From: Liz Annalls [REDACTED]
Sent: 20 January 2020 09:21
To: Planning.Responses <Planning.Responses@arun.gov.uk>
Subject: RE: Planning Consultation on: BE/126/19/PL

App No: BE/126/19/PL

Address: Land at Phase 1A Oldlands Farm Shripney Road Bognor Regis PO22 9NN

Proposal: Erection of a 1410 square metres discount convenience retail food store (Use Class A1) & parking, landscaping & other associated works.

PROPOSED SITE PLAN

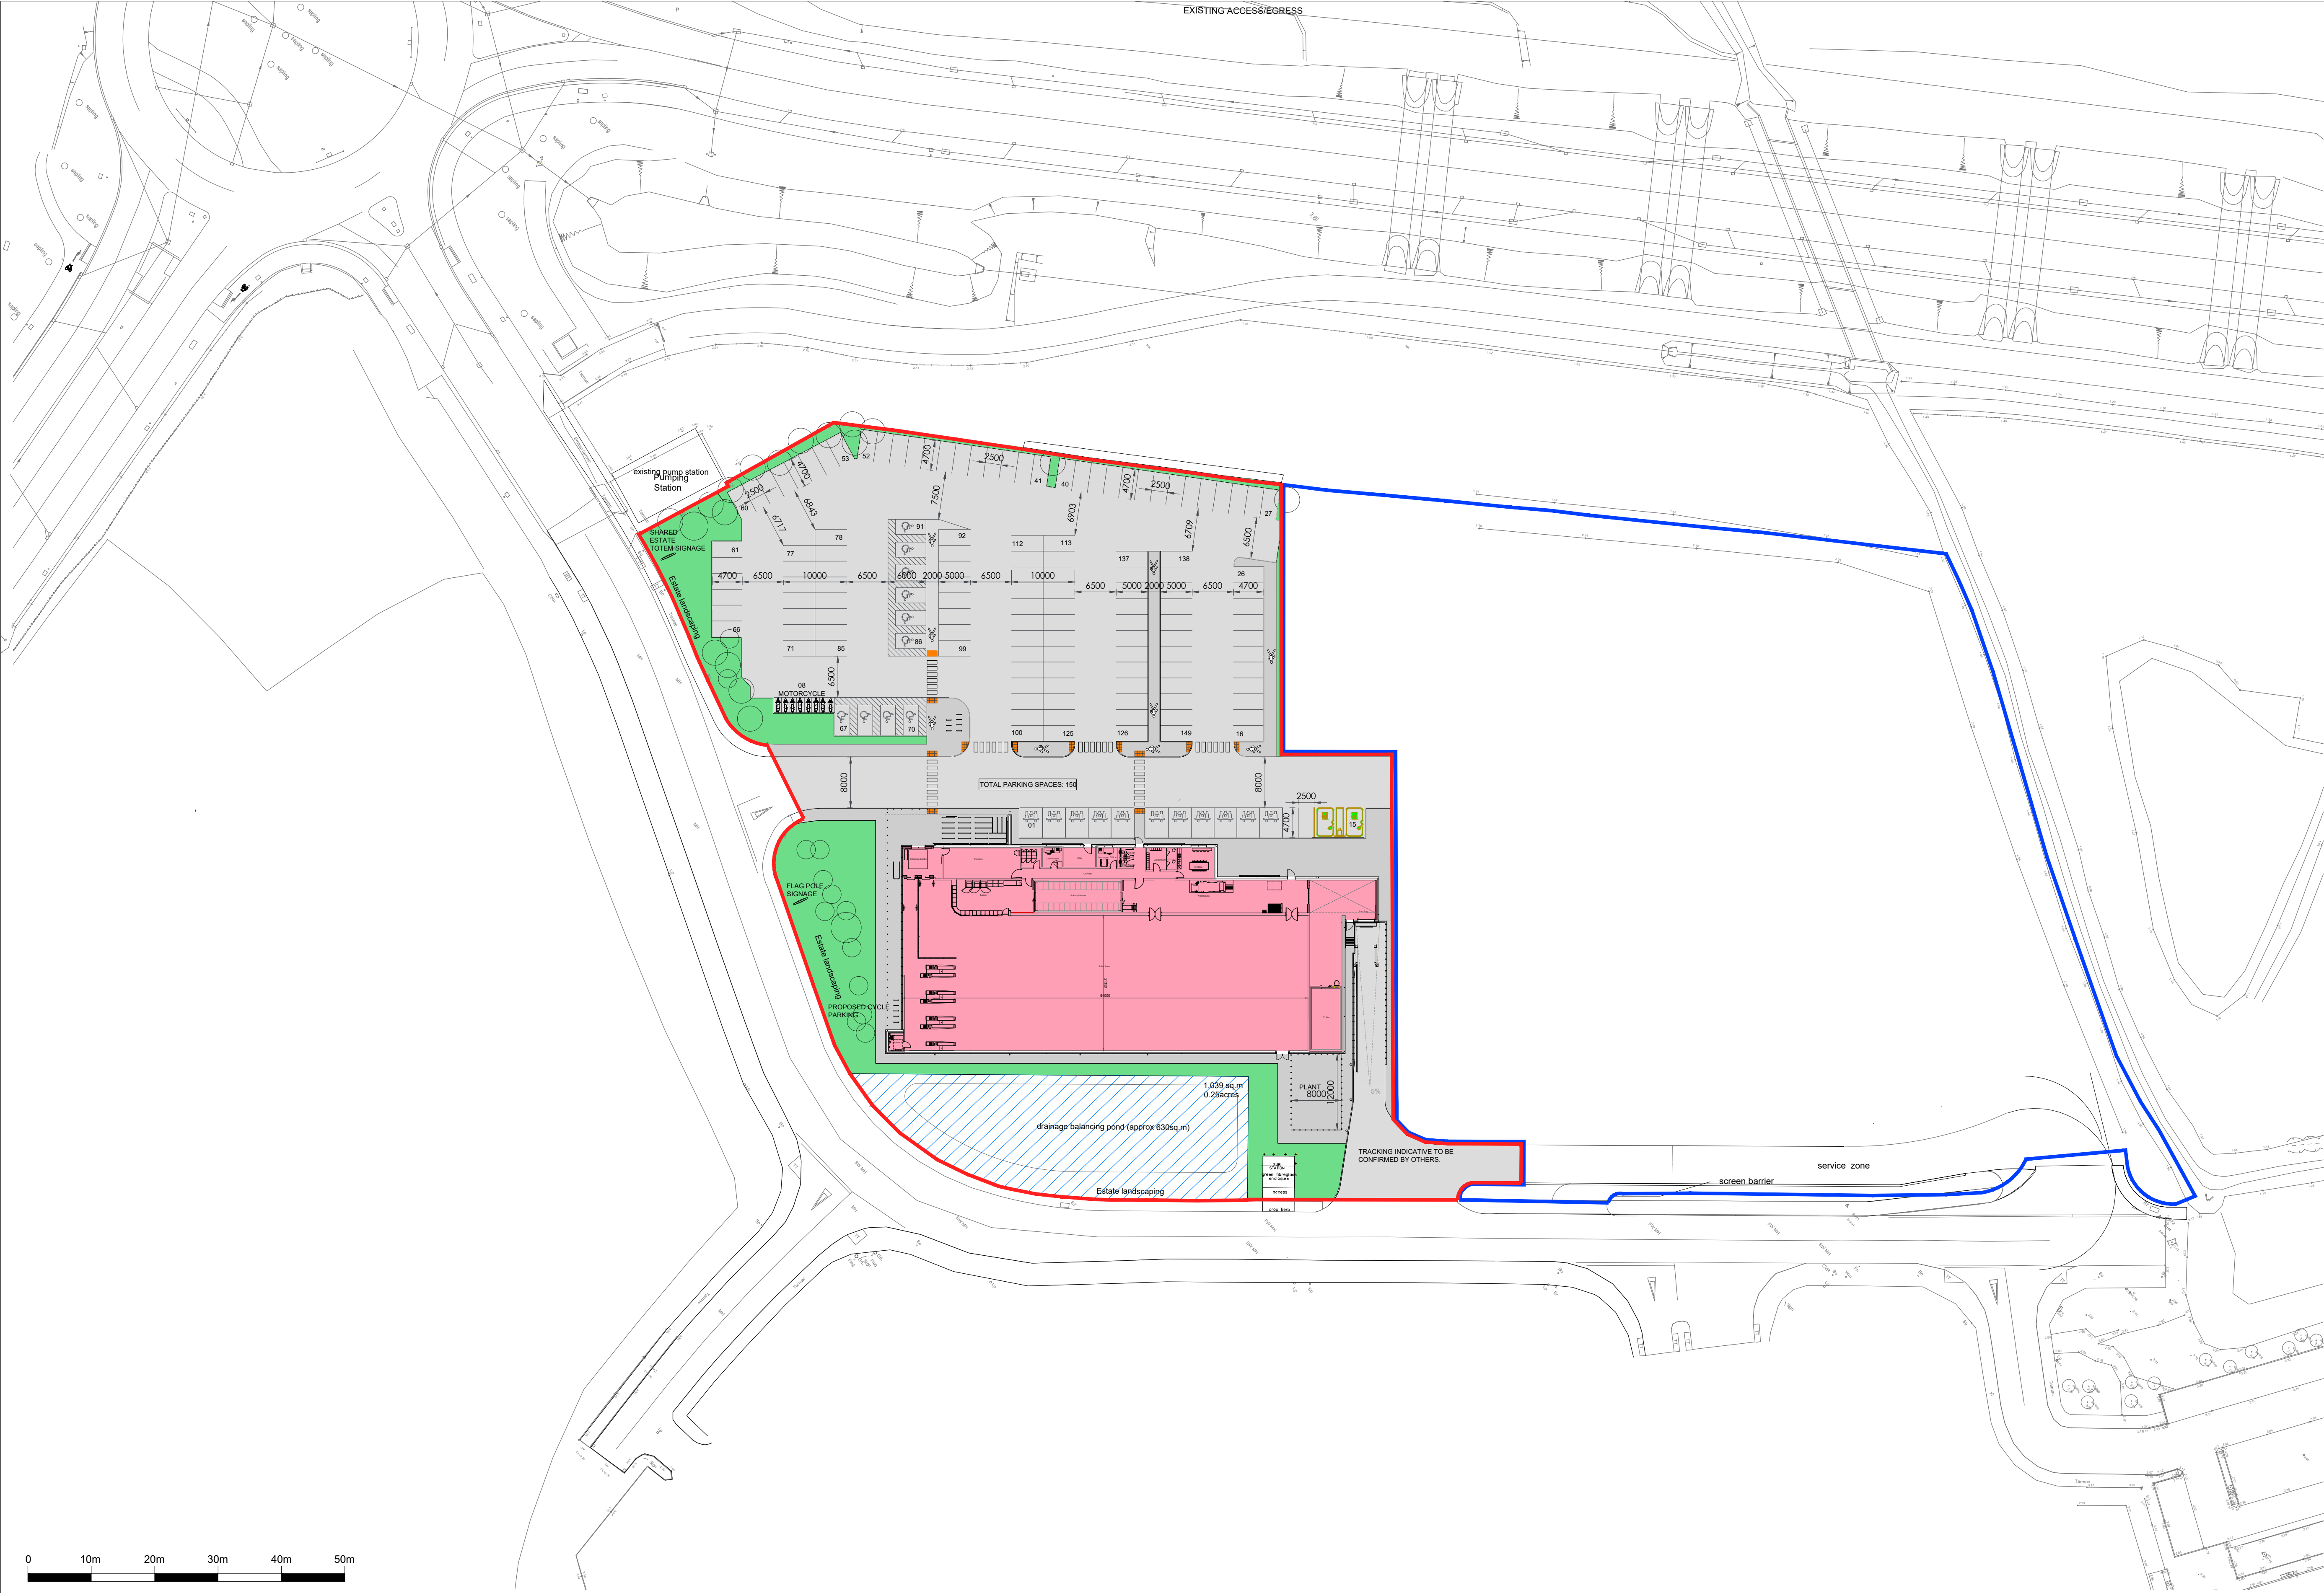
Due to the likely presence of water voles within ditch near to the site precautions should be put in place to ensure no rubble or building waste enters the ditch. As part of the wider area, the ditch needs to be subject to protective measures with a 5m buffer being set up from the ditch bank and fencing used during the construction period to ensure this area remains undisturbed.

We require a number of enhancements are incorporated within the scheme and shown with the landscaping strategy. These include;

- Any trees removed should be replaced at a ratio of 2:1
- Wildflower meadow planting used
- Filling any gaps in tree lines or hedgerows with native species
- Bat and bird boxes installed on the site (as detailed above)
- Grassland areas managed to benefit reptiles.
- Log piles onsite
- We require that gaps are included at the bottom of the fences to allow movement of small mammals across the site
- two hedgehog nesting boxes included on the site

Drawing Title:
PROPOSED ELEVATIONS

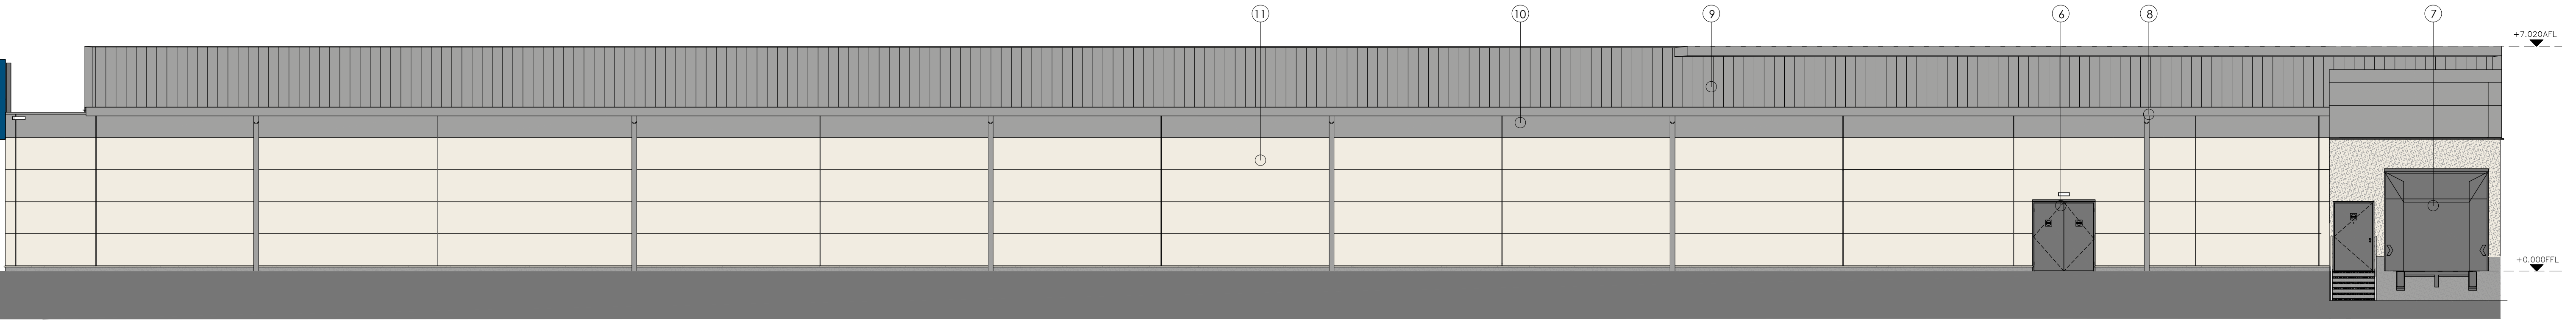
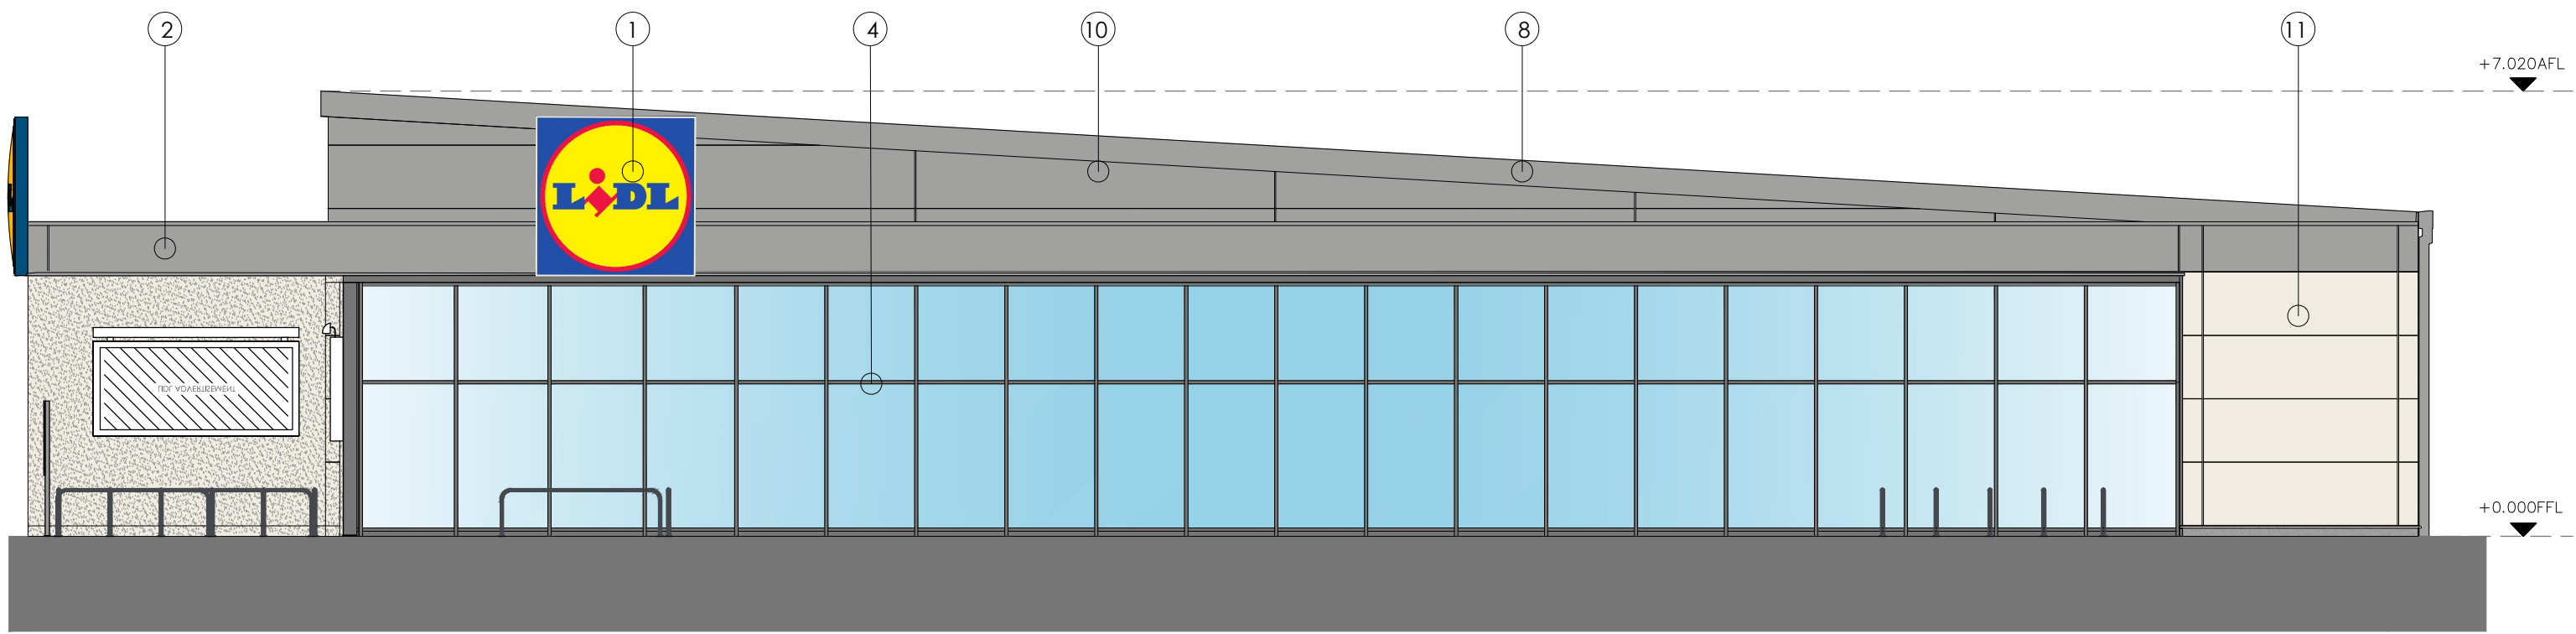
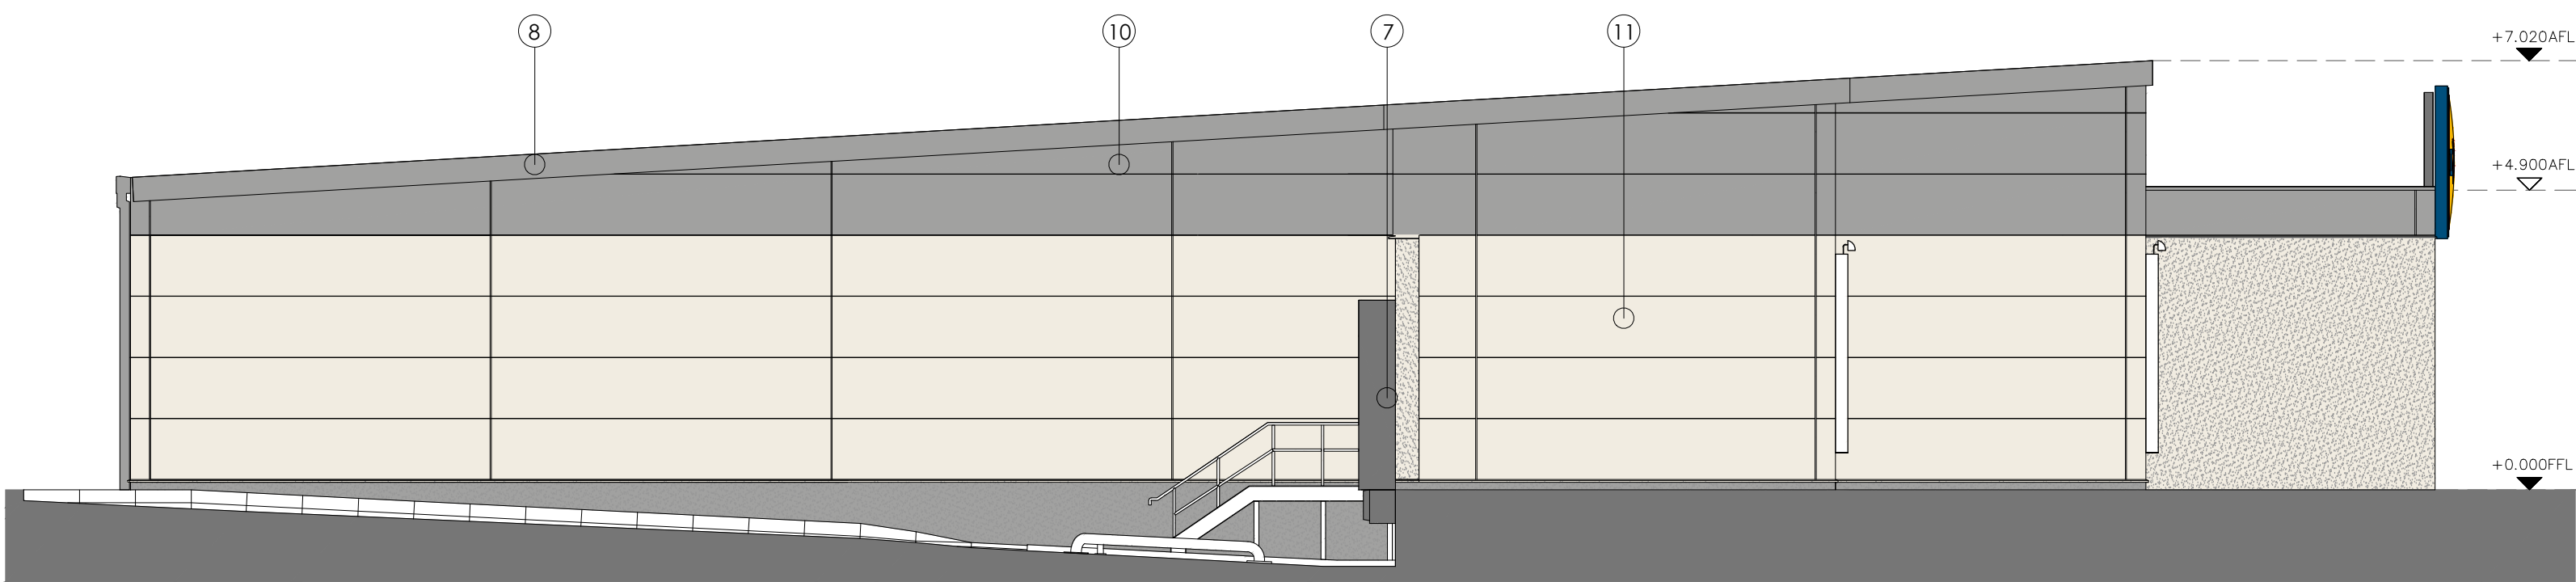
We require that a bat brick is integrated into the building onsite facing south/south westerly positioned 3-5m above ground.

We would like a bird box to be installed on the building and or tree within the garden of the property.
